BEACON LITE ROAD STOCKPILE CONSTRUCTION DRAWINGS AMENDMENT

EL PASO COUNTY, COLORADO

EDARP FILE NO.: CDR261

DRAWN BY:	MGP
SCALE:	N/A
DATE:	12/17/25
JOB NUMBER	25-005
SHEET	1 OF 14

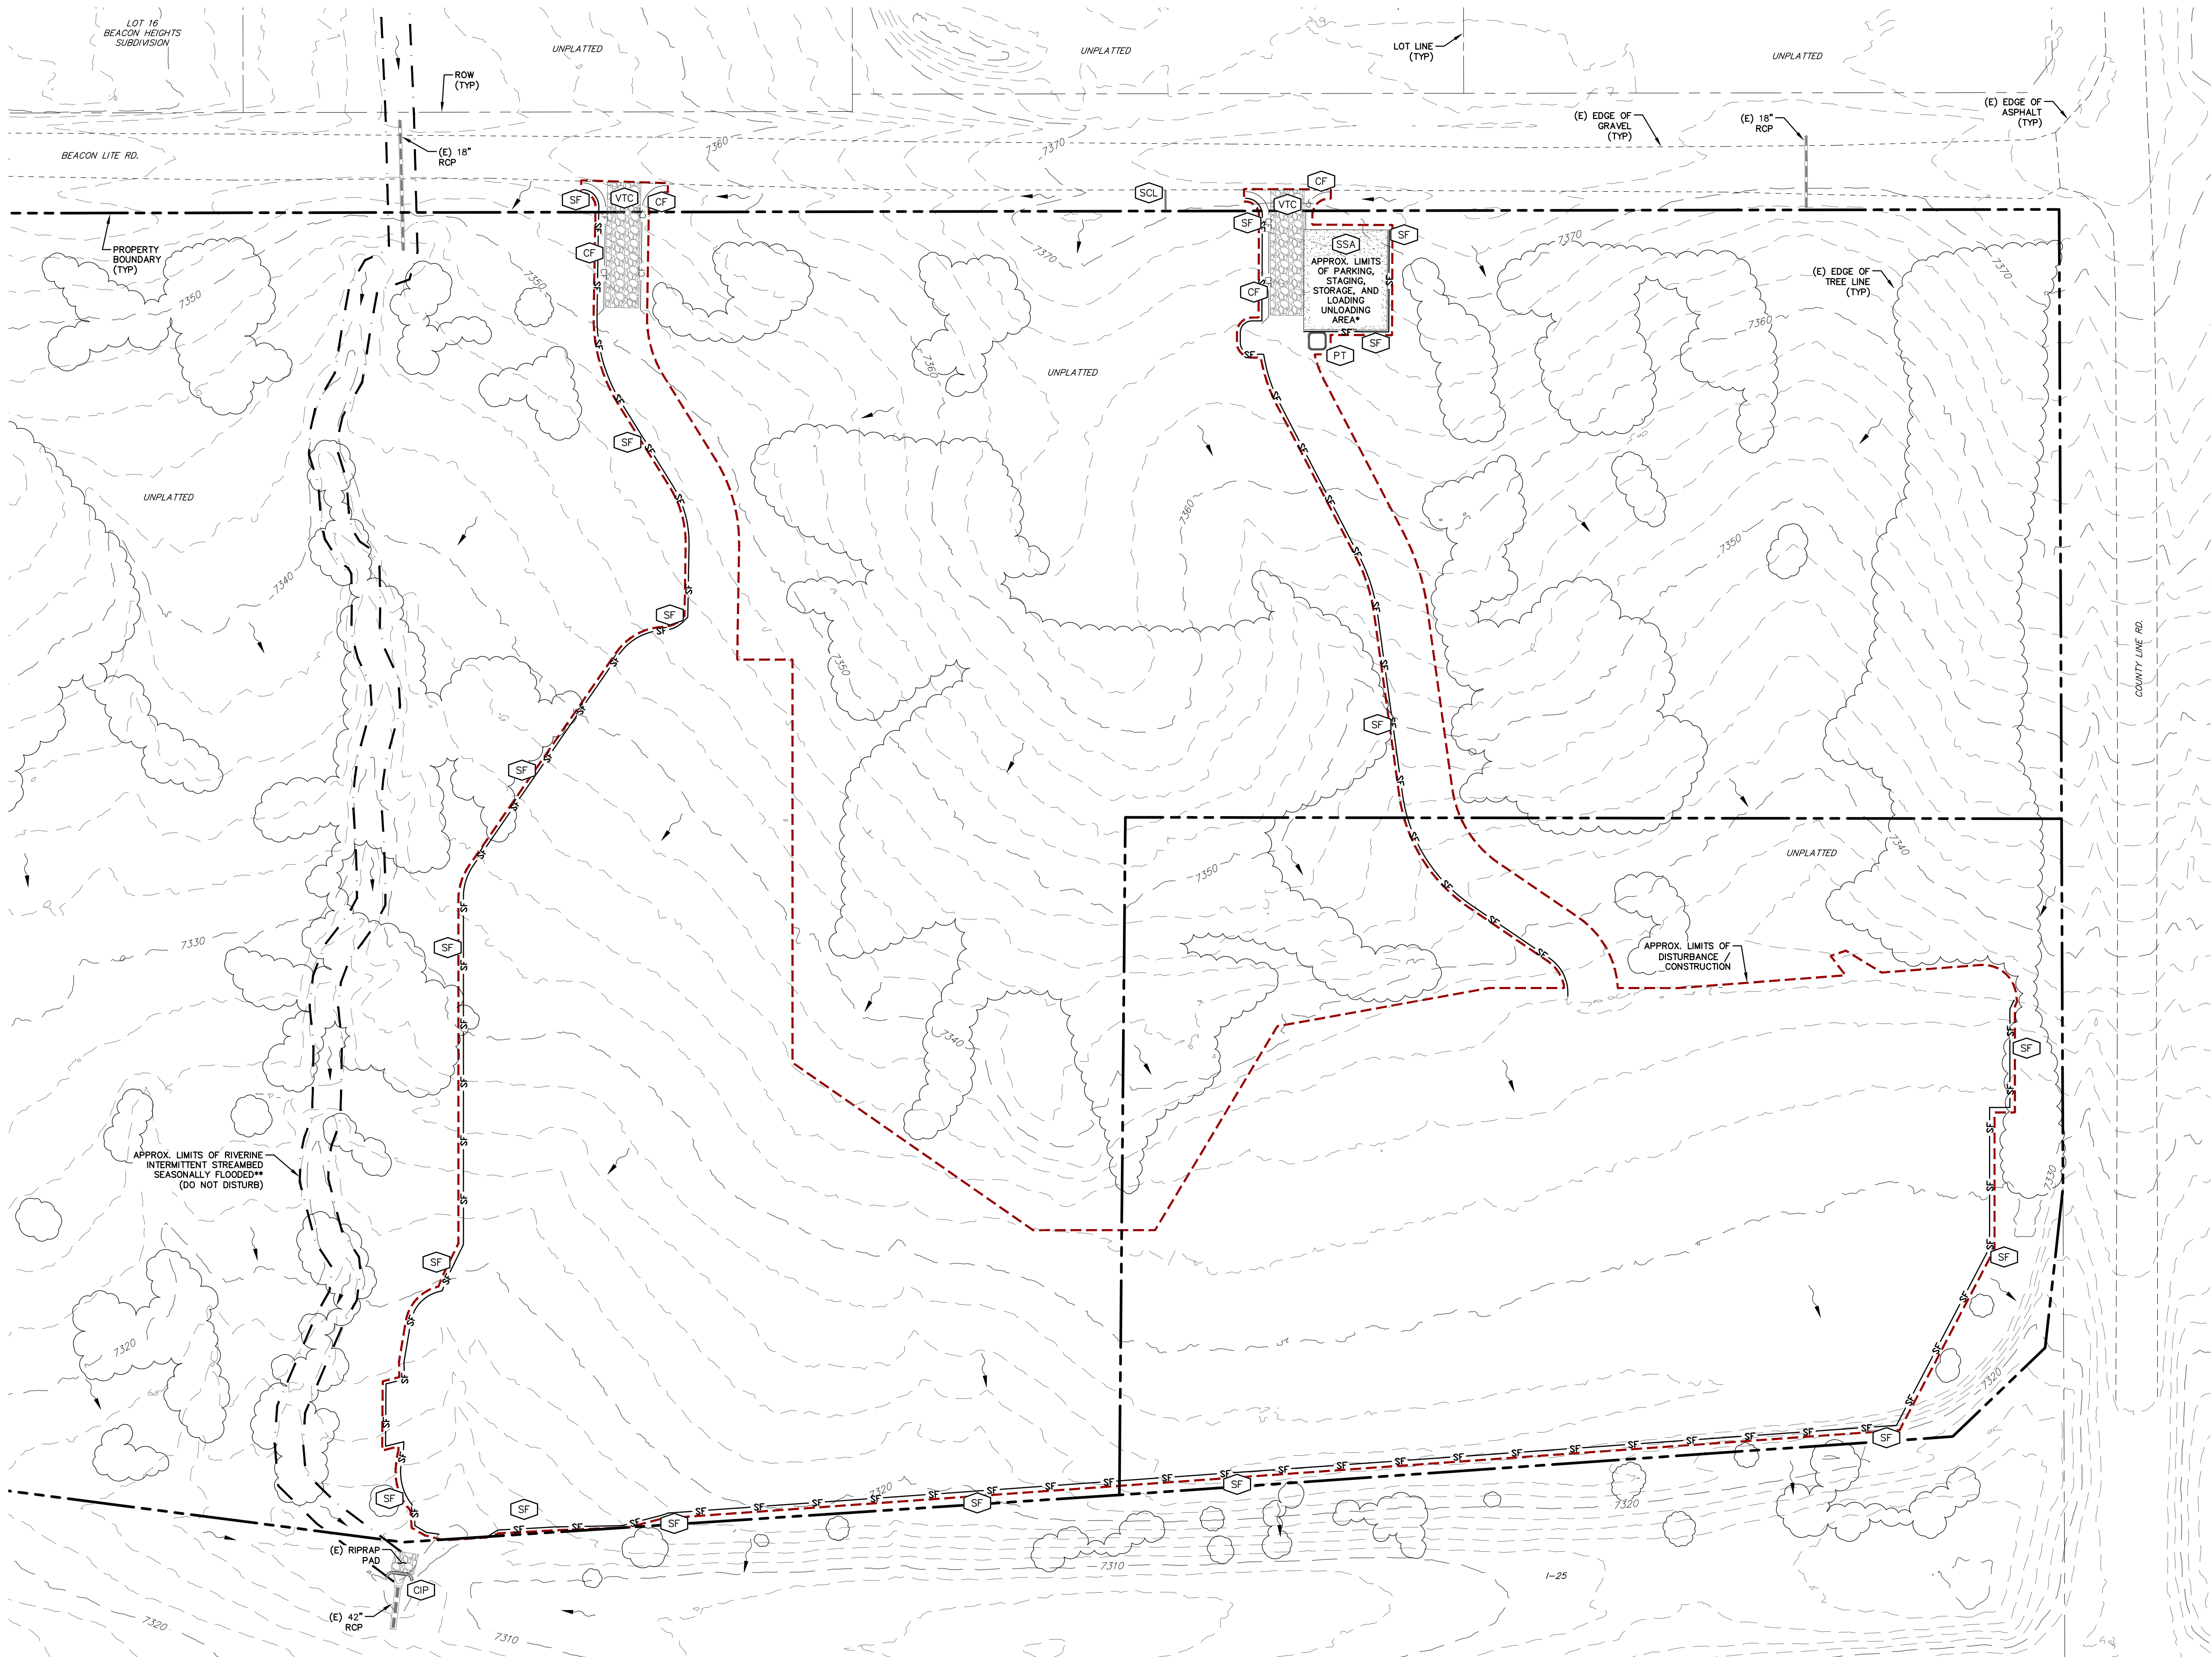
any impacts to the riverine will require coordination and permitting with the army corp.
